Tower Club/Coco Lounge
8-10 Clifton Road
Littlehampton
West Sussex
BN17 5AS

Our Ref: LU/264/18/PL
Your Ref:

Development Change of use from redundant function room to office.
Location 8 - 10 Clifton Road Littlehampton

Address of works: 8-10 Clifton Road, Littlehampton			
Drawing title: Planning permission for change of use			
Date: Oct, 2018	Scales: As shown	Paper size: A1	Dwg No: AR-132B-02

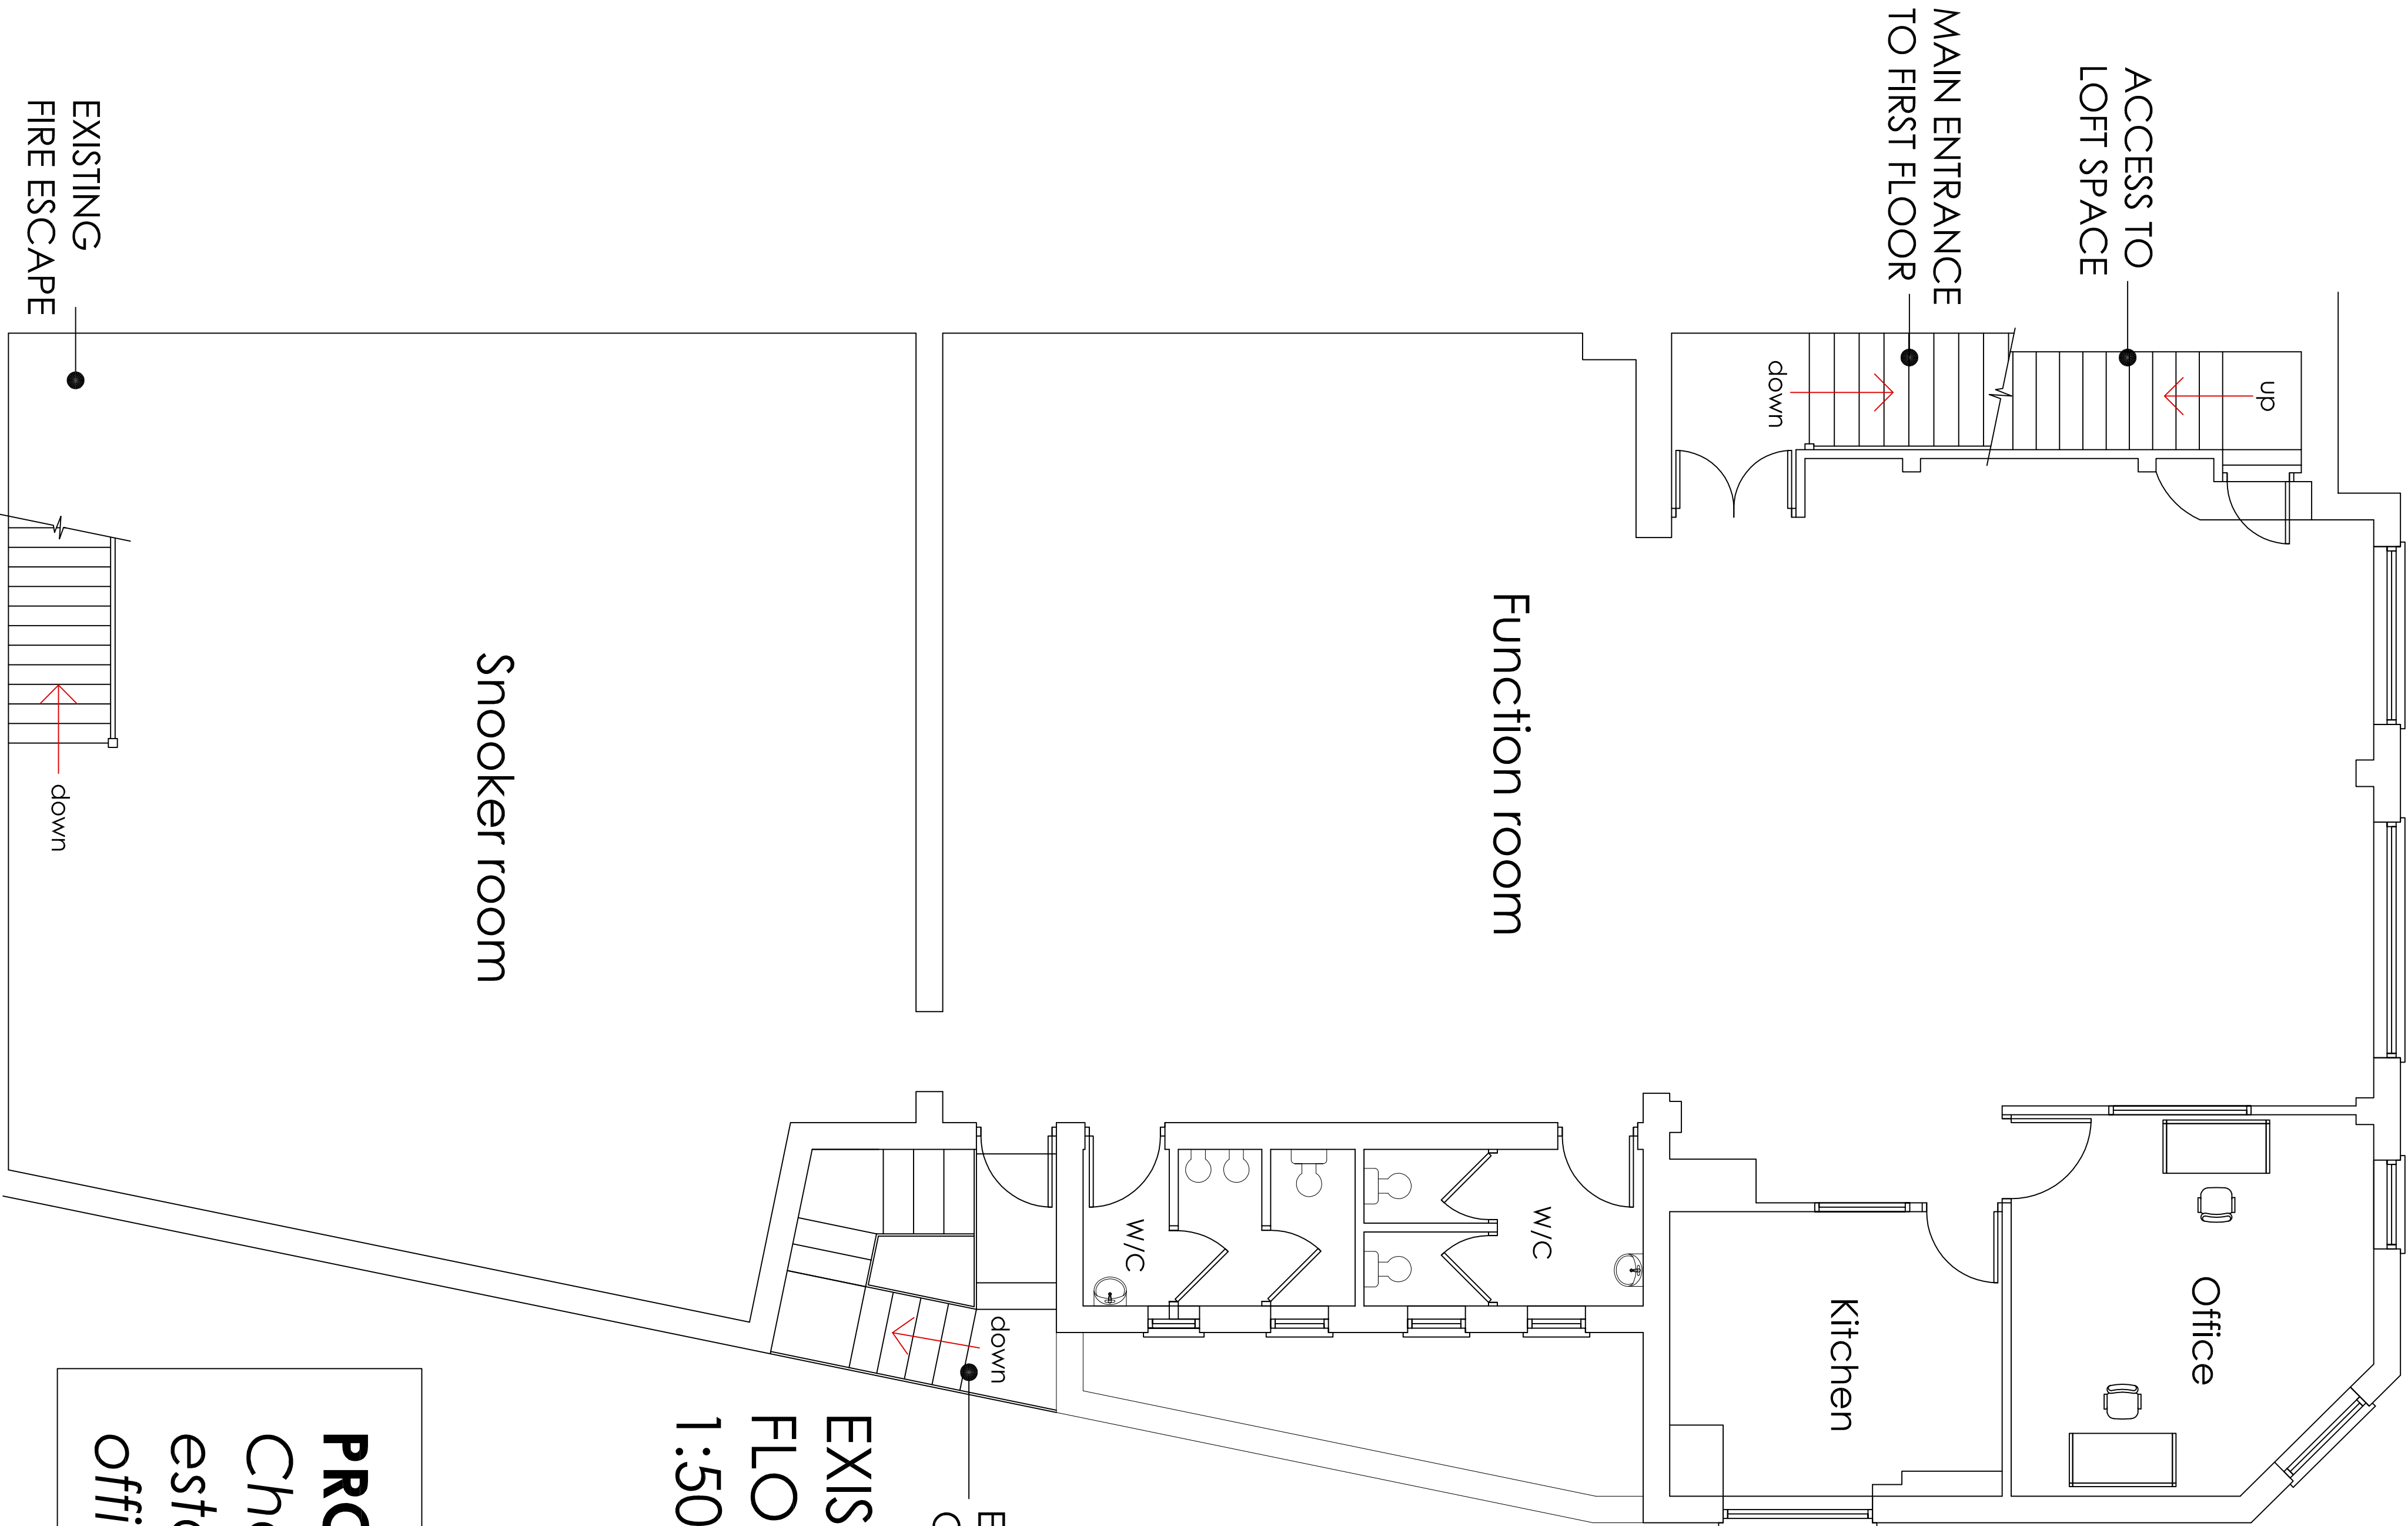
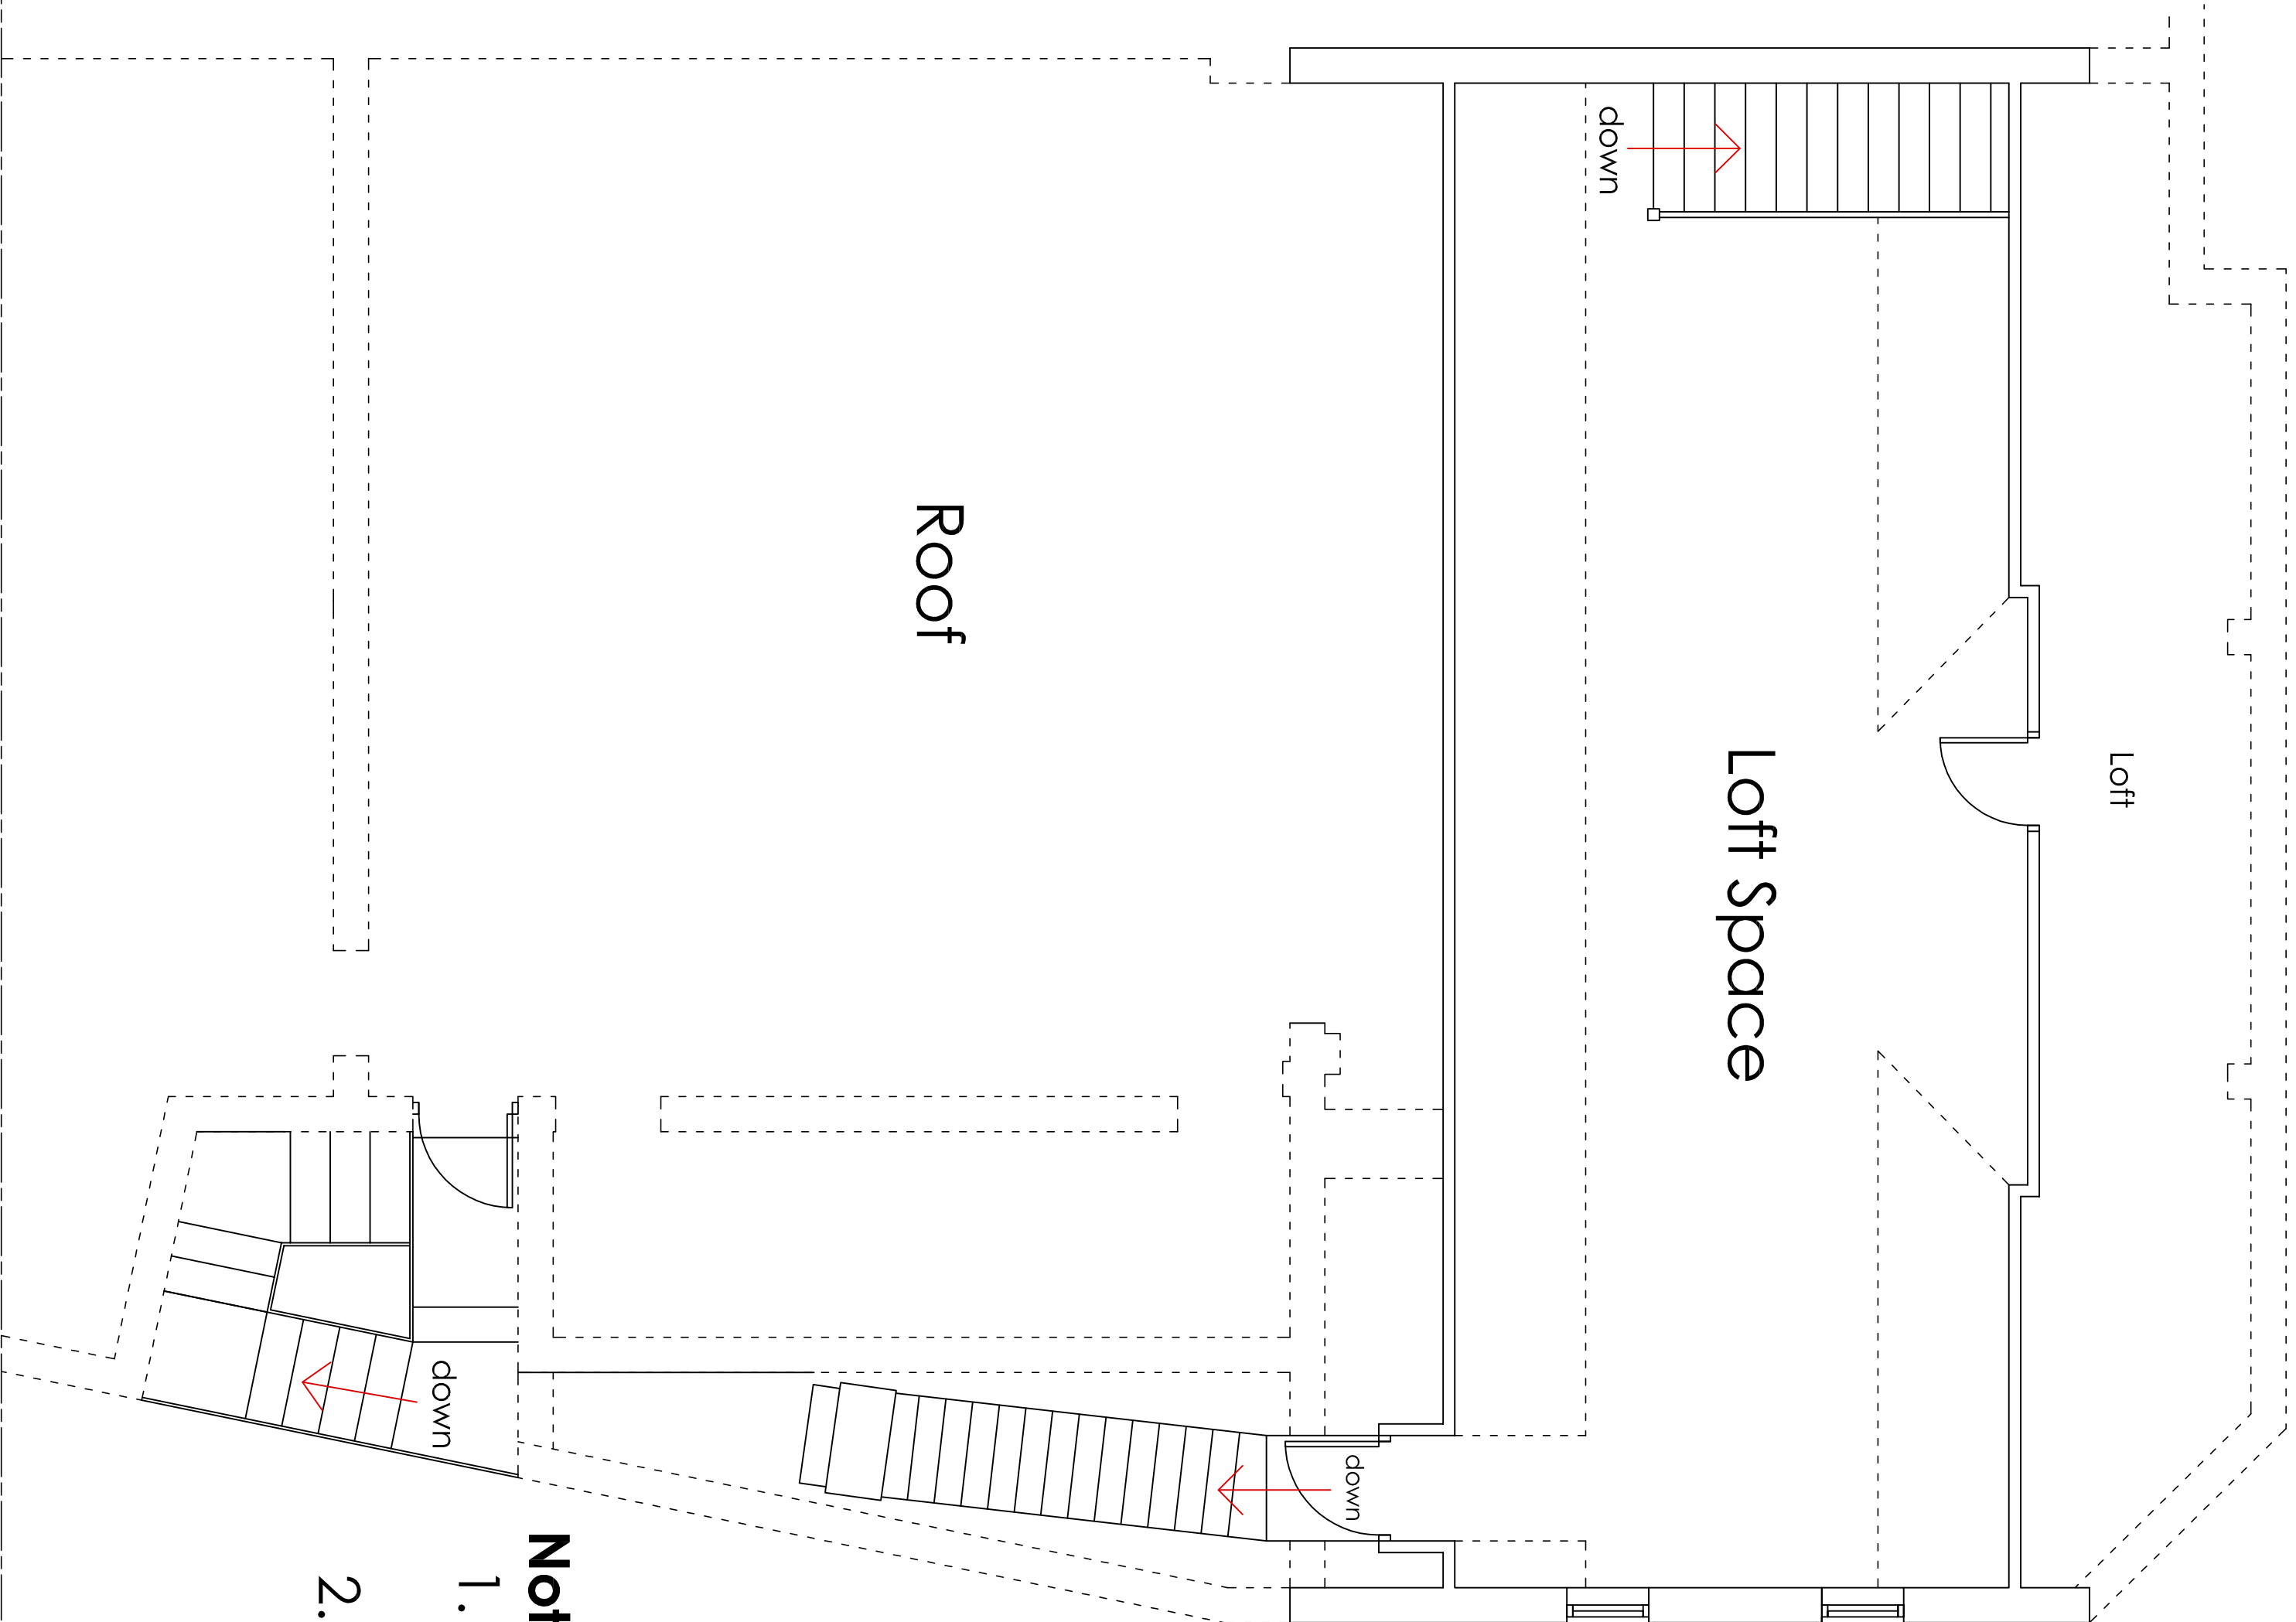
Please provide a scale for the existing and proposed floor plans (the plans that were submitted on A3 paper) and provide a scale or measurements on the plans.

SITE PLAN 1:500

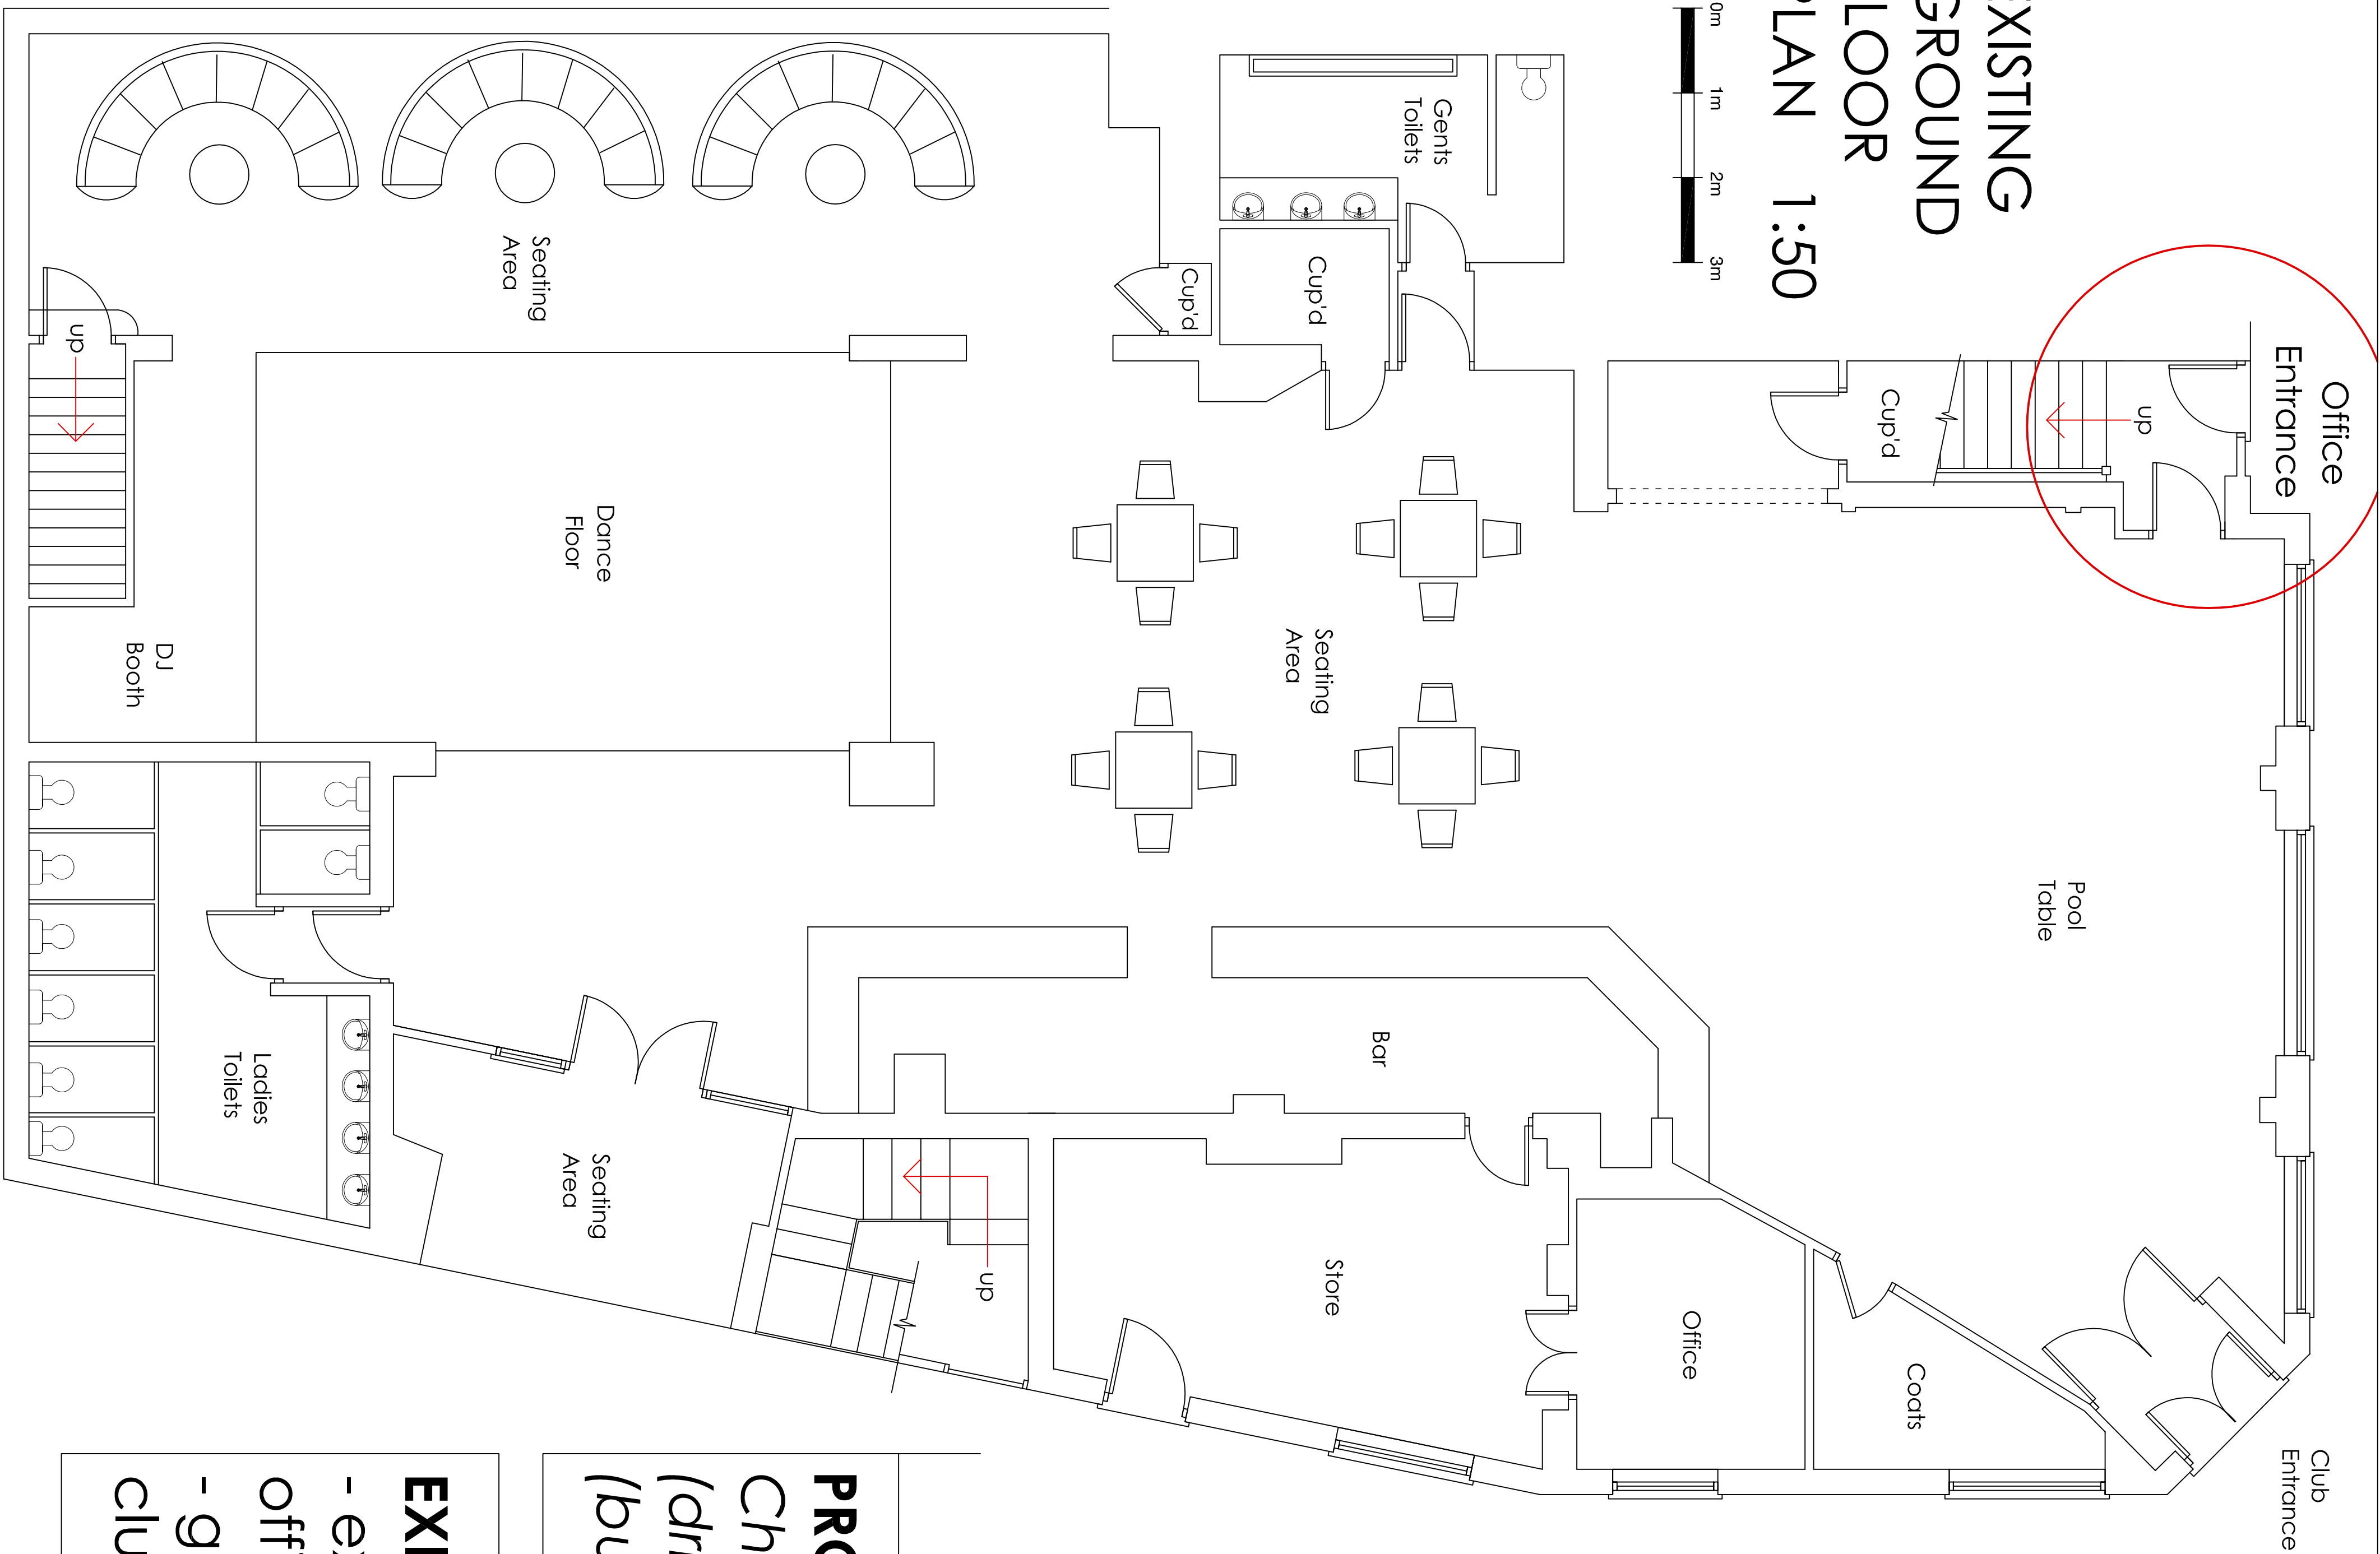
Block Plan Amend

Please hatch the area of the proposed office.
